**STATEMENT OF ENVIRONMENTAL EFFECTS: SECTION 75W APPLICATION, MODIFICATIONS
TO MAJOR PROJECT MP NO.10_0158 (BUILDINGS 7 & 8) – 61 MOBBS LANE, EPPING**

Pursuant to Section 75W (1) (a) of the Environmental Planning and Assessment Act 1979, a 'modification of approval' is sought to vary Condition No. A2 pertaining to Major Project MP No. 10_01581 (Buildings 7 & 8) as approved on the 12 July 2011. The modification is to amend architectural plans to accommodate minor design changes.

Epping Park
61 Mobbs Lane, Epping
Stage 1 (Building 7+8)
A8201
PROJECT
APPLICATION

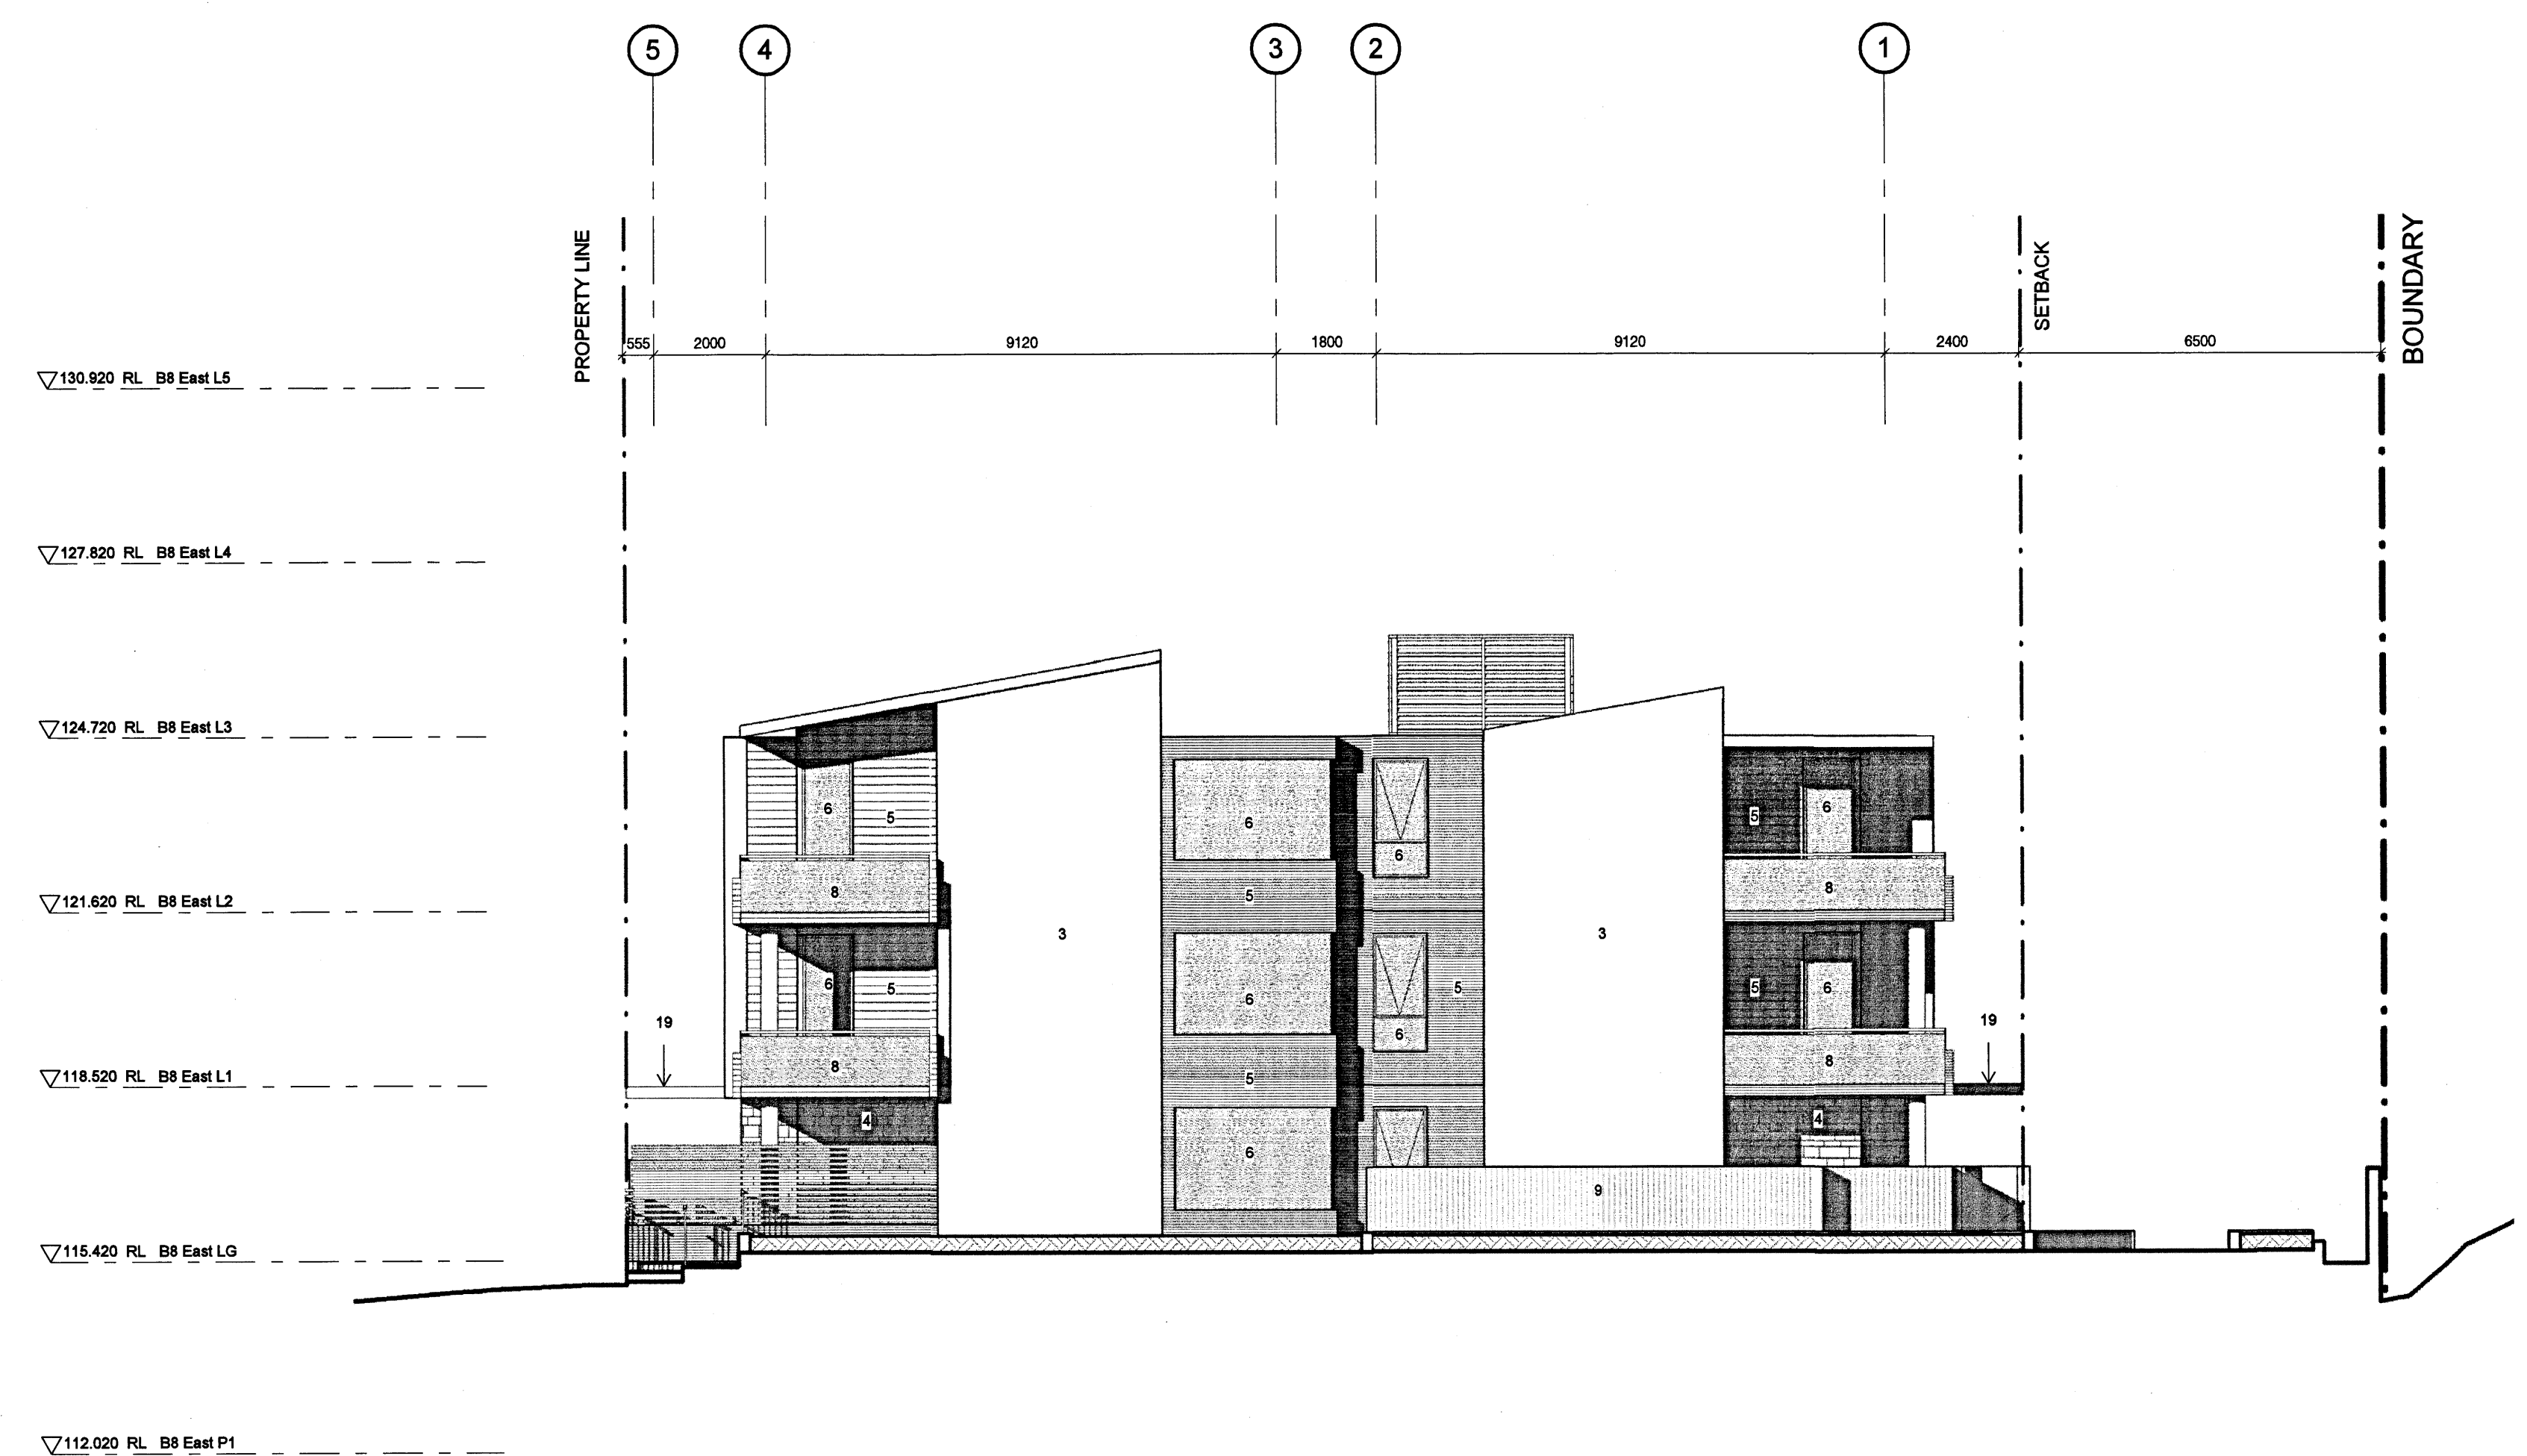
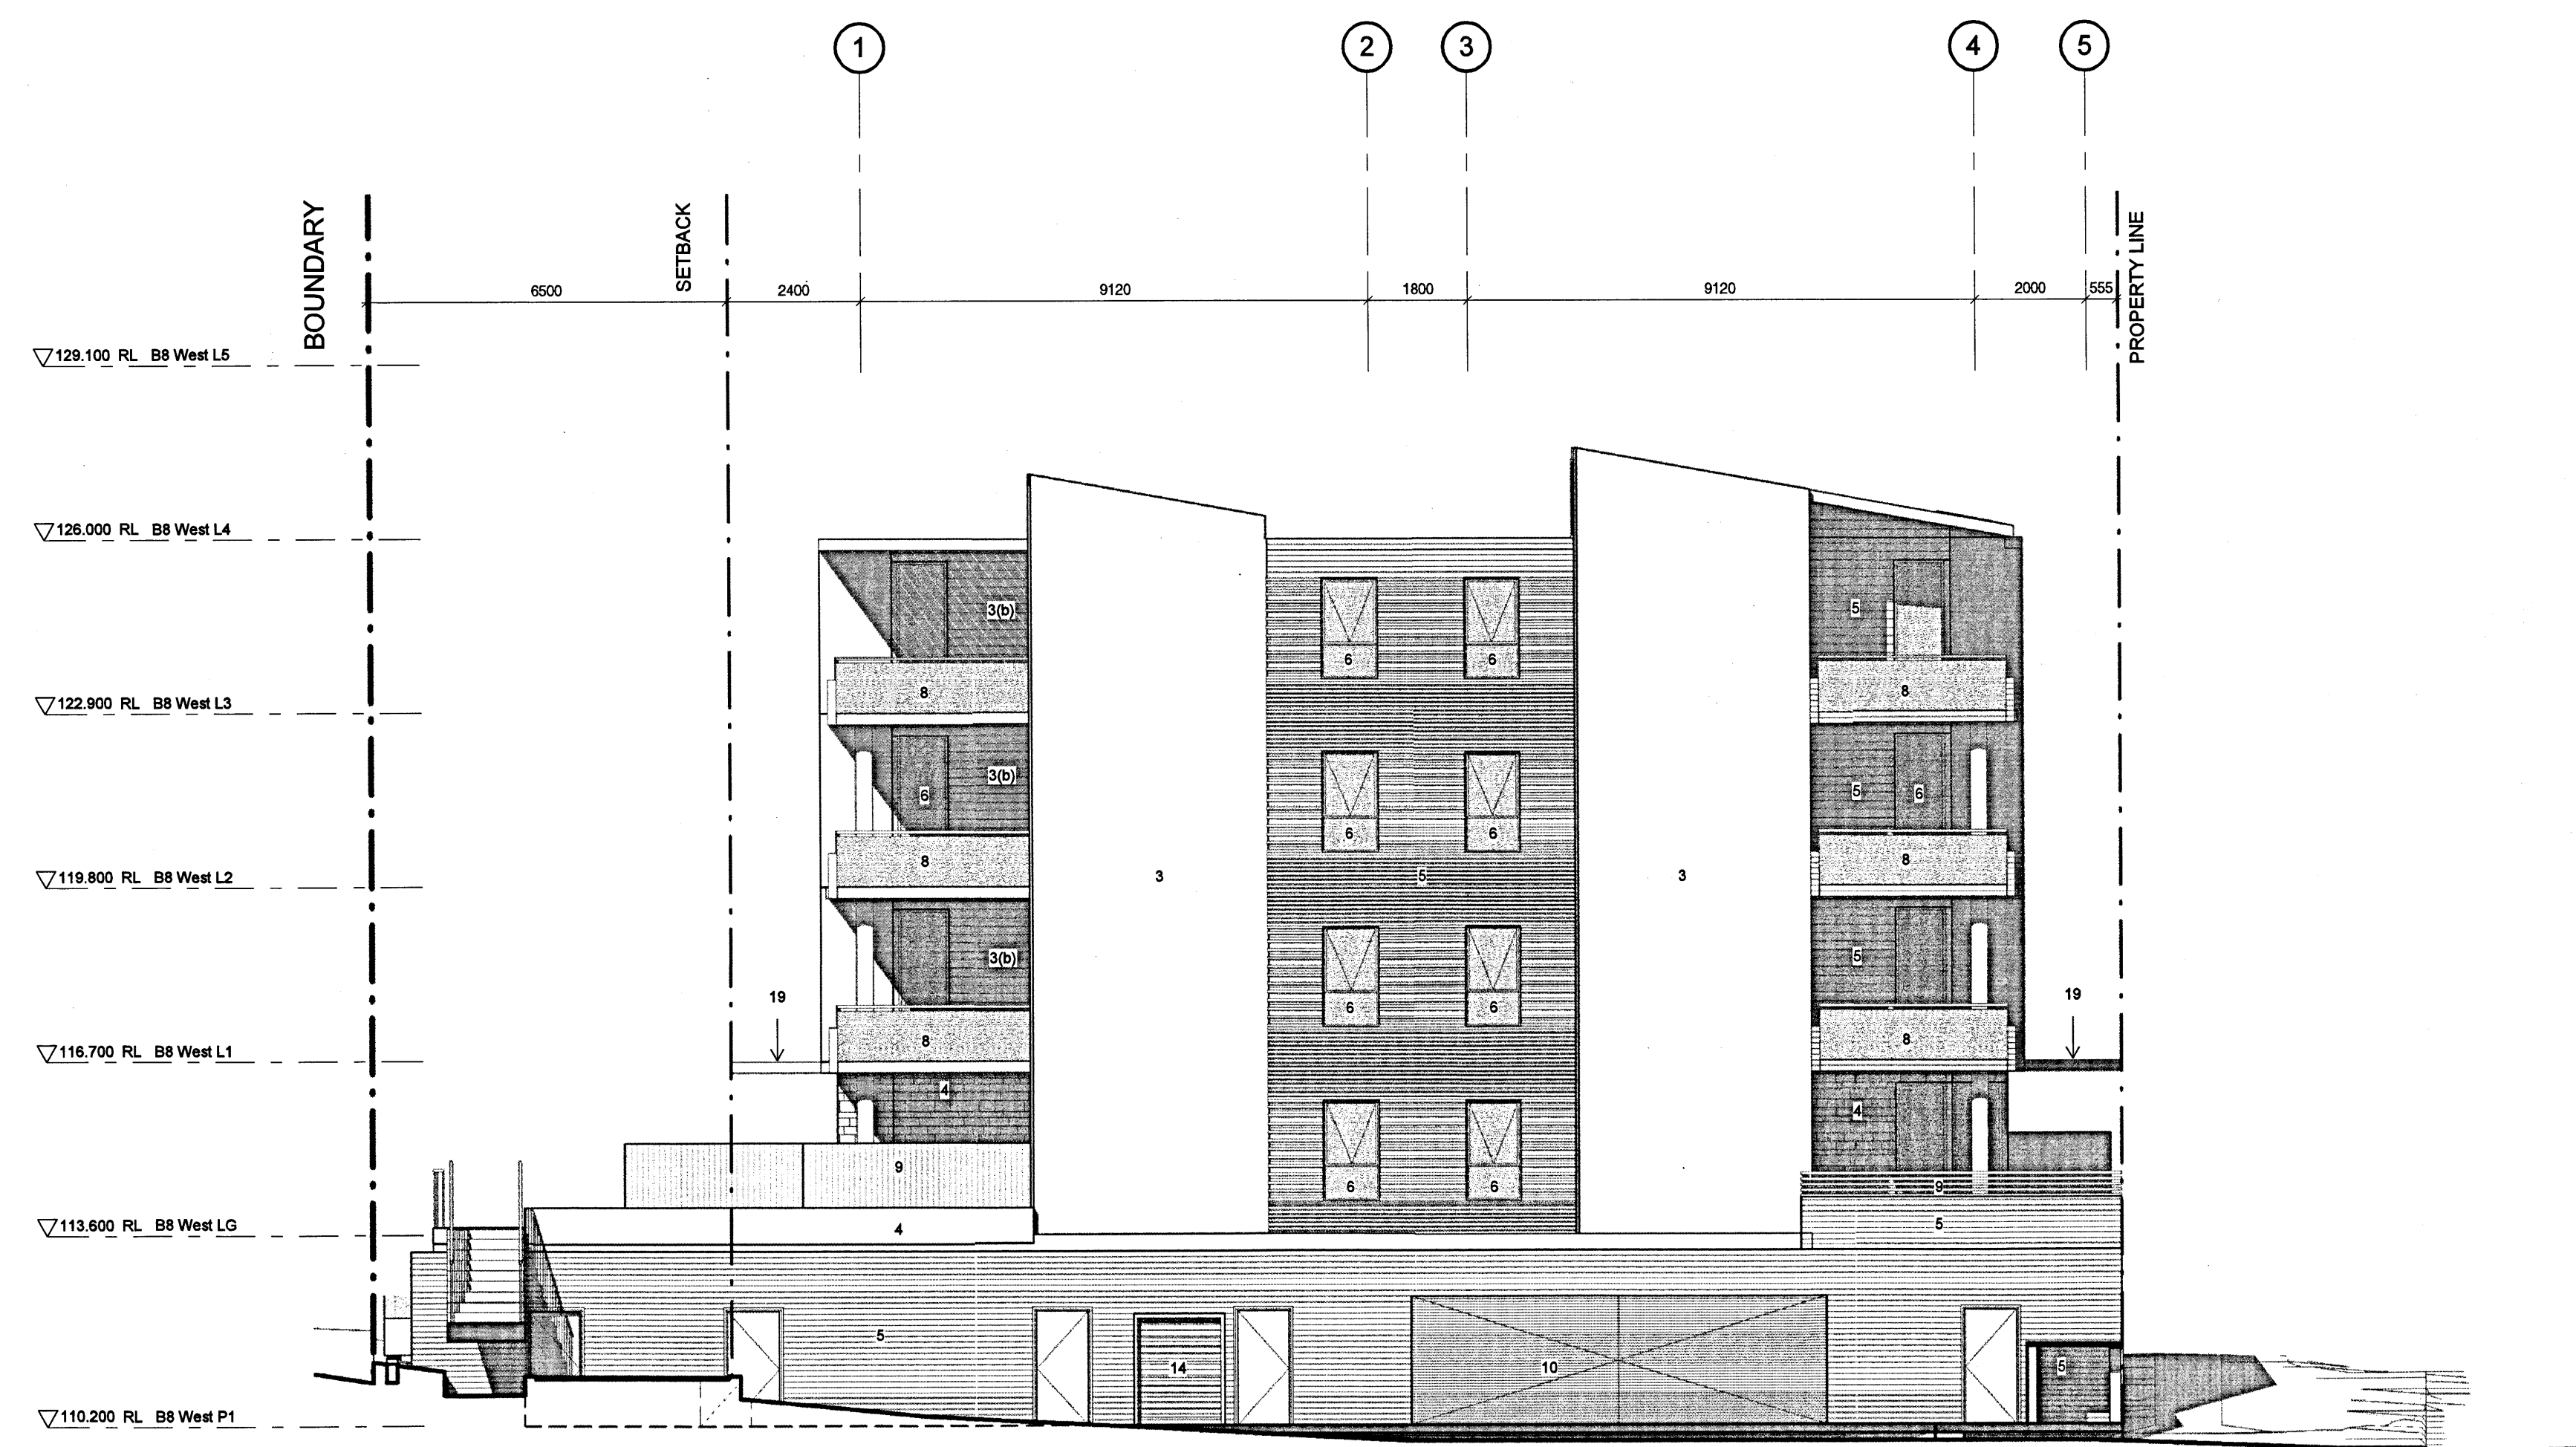
B8 Elevations, Sheet 1, A8200	B8 Elevations, Sheet 1, A8200, Rev A 7. Reconfiguration of louvre screens 8. Relocation of access
B8 Elevations, Sheet 2, A8201	B8 Elevations, Sheet 2, A8201, Rev A 3. Modification to unit 7. Reconfiguration of louvre screens 8. Reconfiguration of courtyard fences 9. Relocation of access

B8 Elevations, Sheet 2, A8201 The current elevation pertaining to Unit 108 indicates a solid blank wall.	B8 Elevations, Sheet 2, A8201, Rev A The elevation indicates the fence as a continuation of the existing fence line therefore providing a more consistent finish.
